PAD-3

PADMARK BUSINESS PARK-LOT 3
1190 MEADOWBROOK PKWY
COLORADO SPRINGS, CO 80915
EL PASO COUNTY, COLORADO

DATE: JULY 10, 2018
DRAWN BY: A. MCKENZIE
PROJ. MGR: Z. GRABTREE
SCALE: SEE PLAN
APPROVED BY:
JOB NO: 1060

▲ 9-20-18/COMMENTS 8-8-18

**PROJECT INFORMATION**

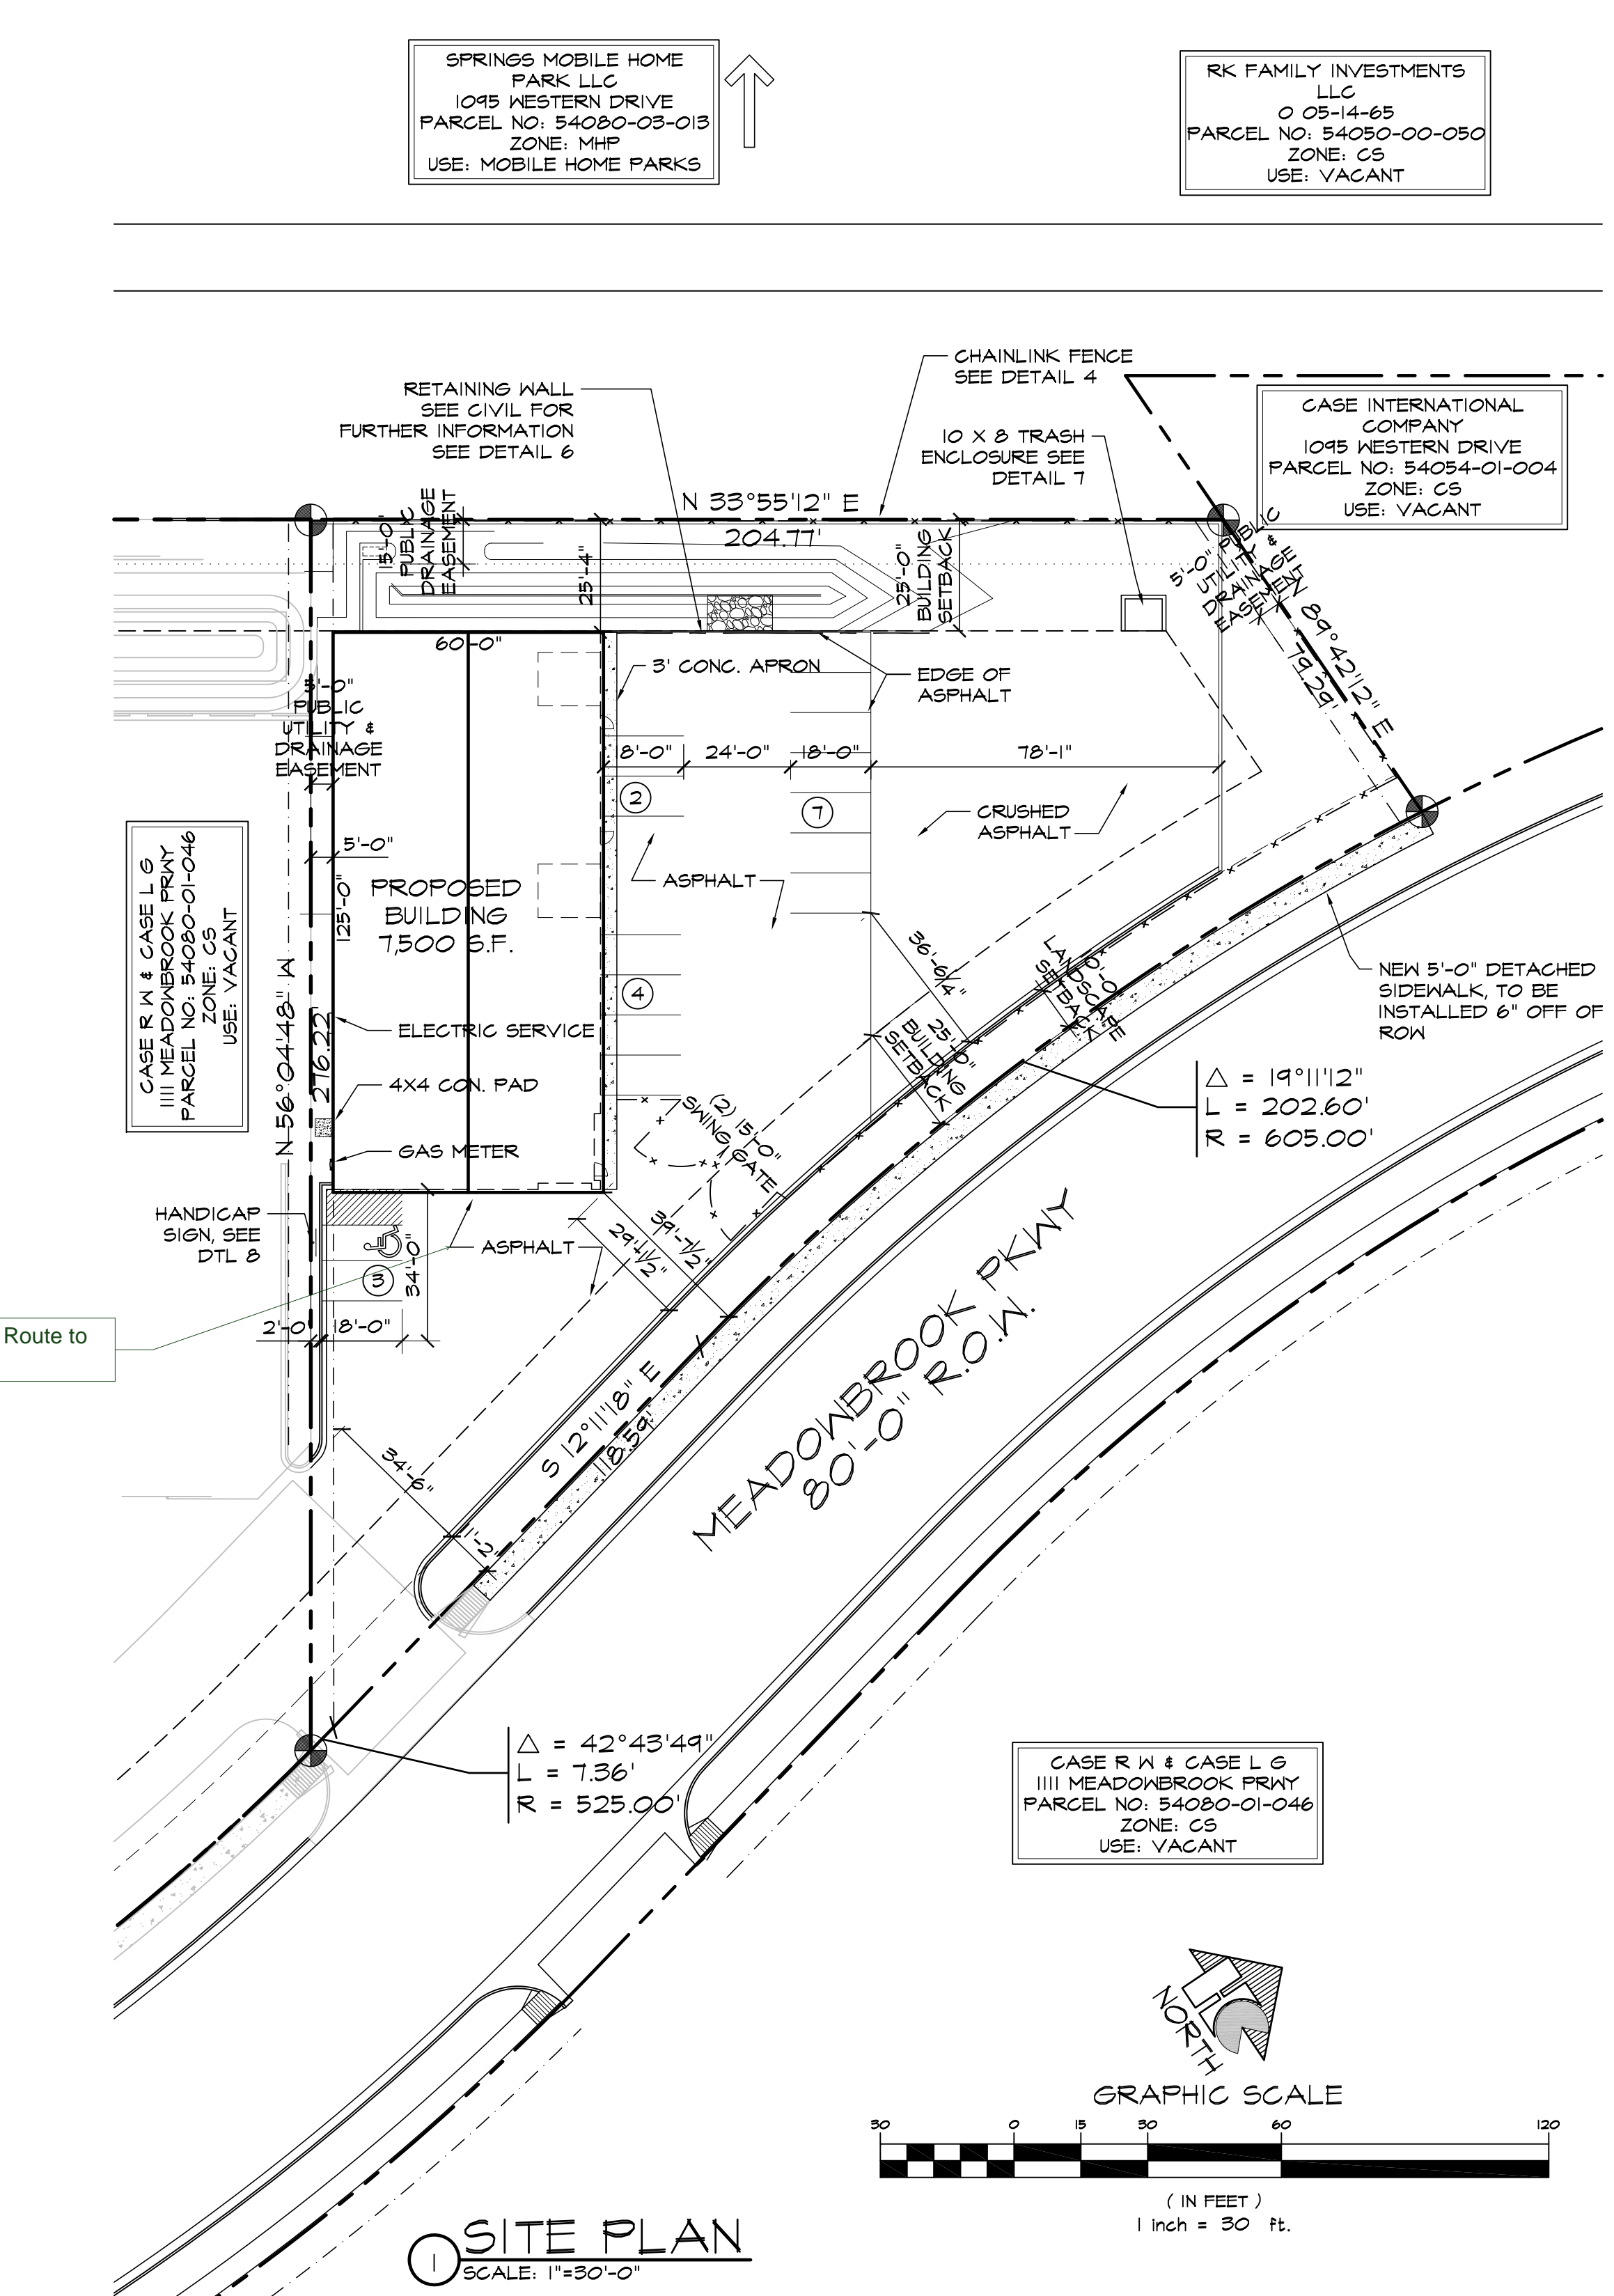
Show 5' side setback.

Show 5' side setback.
